FIRE FLOW ASSESSMENT REPORT

8520 McArton Road, Ottawa

Revision 3 June, 2023

RE: FW: File: D07-12-19-0145 (Ottawa Valley Wild Bird Care Centre)

TANK - TOP VIEW
 SCALE 1:50

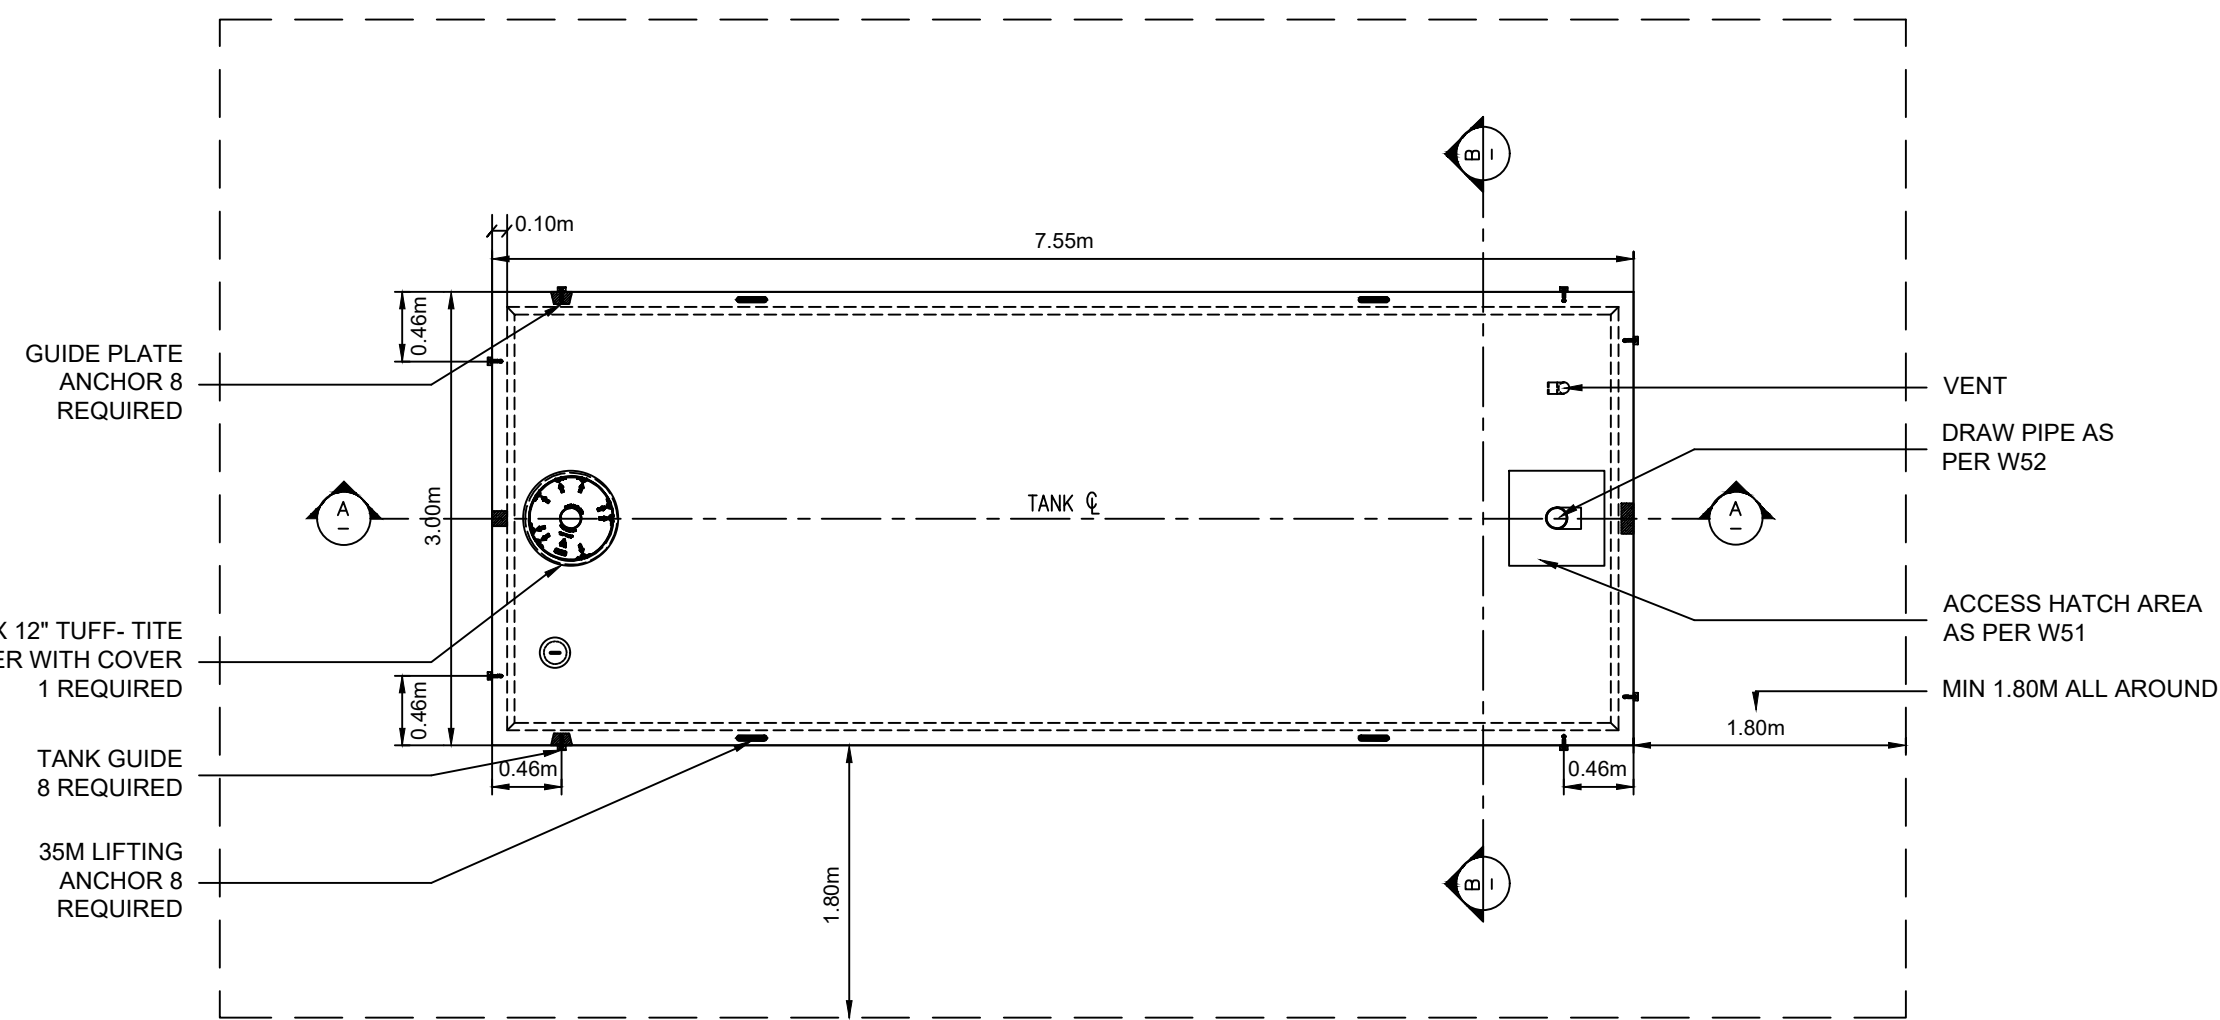
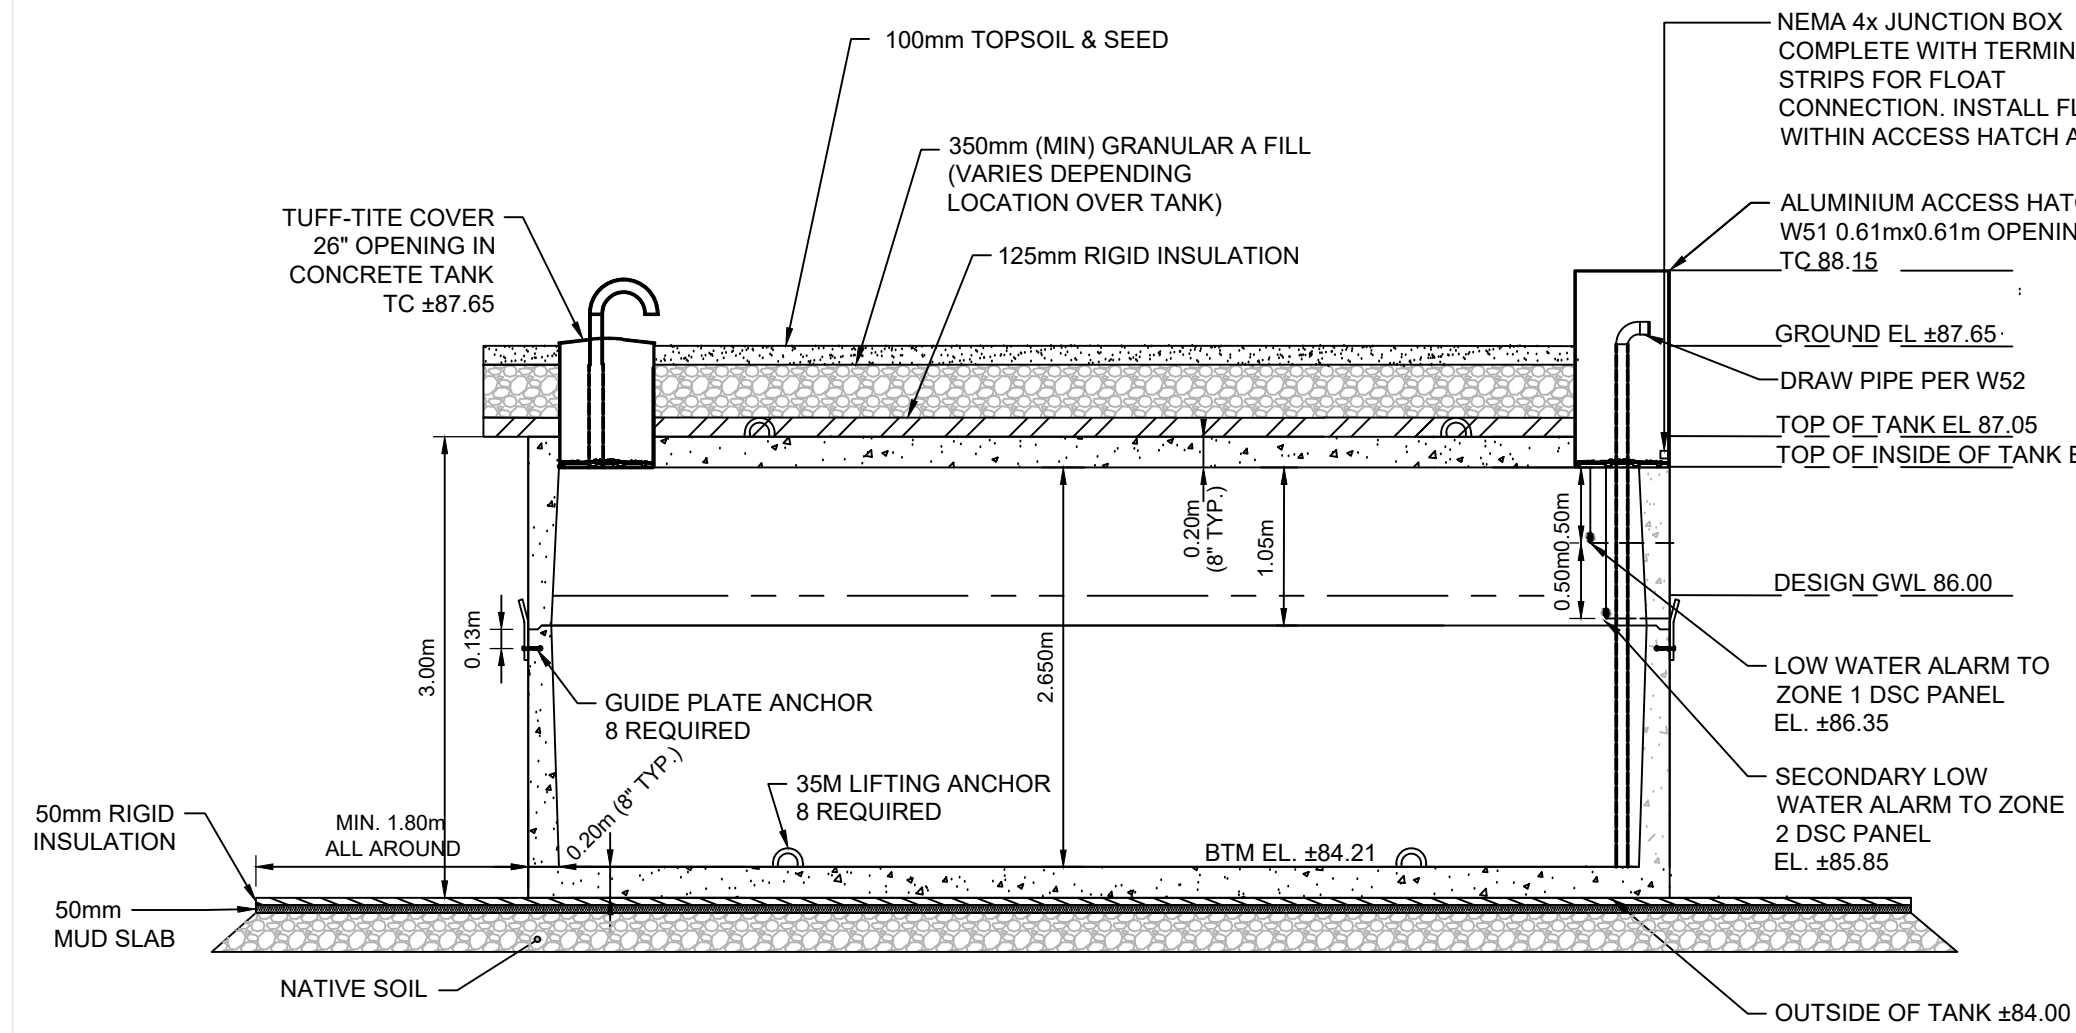
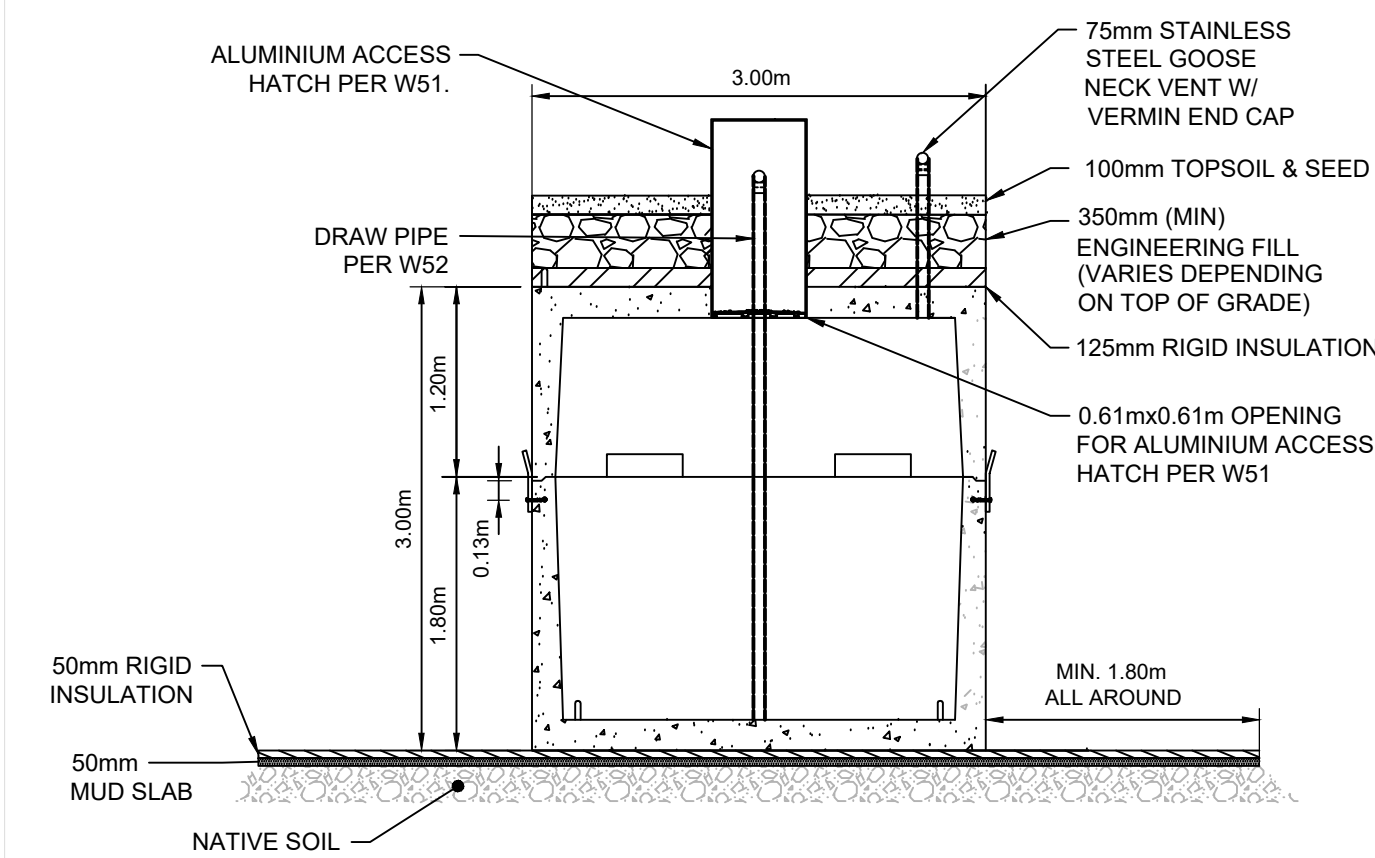
- 2. Hydrant type. As we have a draft hydrant, it is important to make sure the correct hydrant is used for the application. It must be capable of drafting (negative pressure) and have the correct adapter on it for our trucks (if W51-W54 have not been provided, please let me know). It is also important to note the water table in this area. If there is a chance that the hydrant bottom (where the pipe goes parallel to the tank) will be within the water line (especially in colder months), the fire hydrant must have sealed weep-holes. If the water table is safely below this level, then a normal operating hydrant is fine. The purpose is that when the hydrant is Closed (prevents water from coming from tank), the weep holes open so that the stem (riser) of the hydrant will drain out the bottom and stays dry in winter, it will not freeze. If the water table is high, then ground water could rise up and potentially freeze and damage the hydrant.

- 3. Storage tank filling how will the 50000L tank be filled? The tank is "remote" which is fine for the draft portion of our operations, but we also have a requirement to be able to fill the tank both during firefighting operations and after we are done at a fire at that location. In a standard

setup, we have a blue box on top of the tank directly and they install a 90 degree elbow directed downwards into the tank with a 100mm storz adapter on the outside (see below). We would connect our hose to this adapter and pump water down into the tank to fill. For this setup, the tank is remote from the draft hydrant. They could provide a fill pipe with adapter at that location sort of adjacent to it and run more pipe back to the tanks, but this could lead to a similar freezing issue with the water level rising within the pipe to the same level as the tank itself. They could also put a pipe with the adapter above the tanks provided we were able to get to it. We have lots of hose to run water to the tanks, we just need the ability to get to those tanks (on foot is fine).
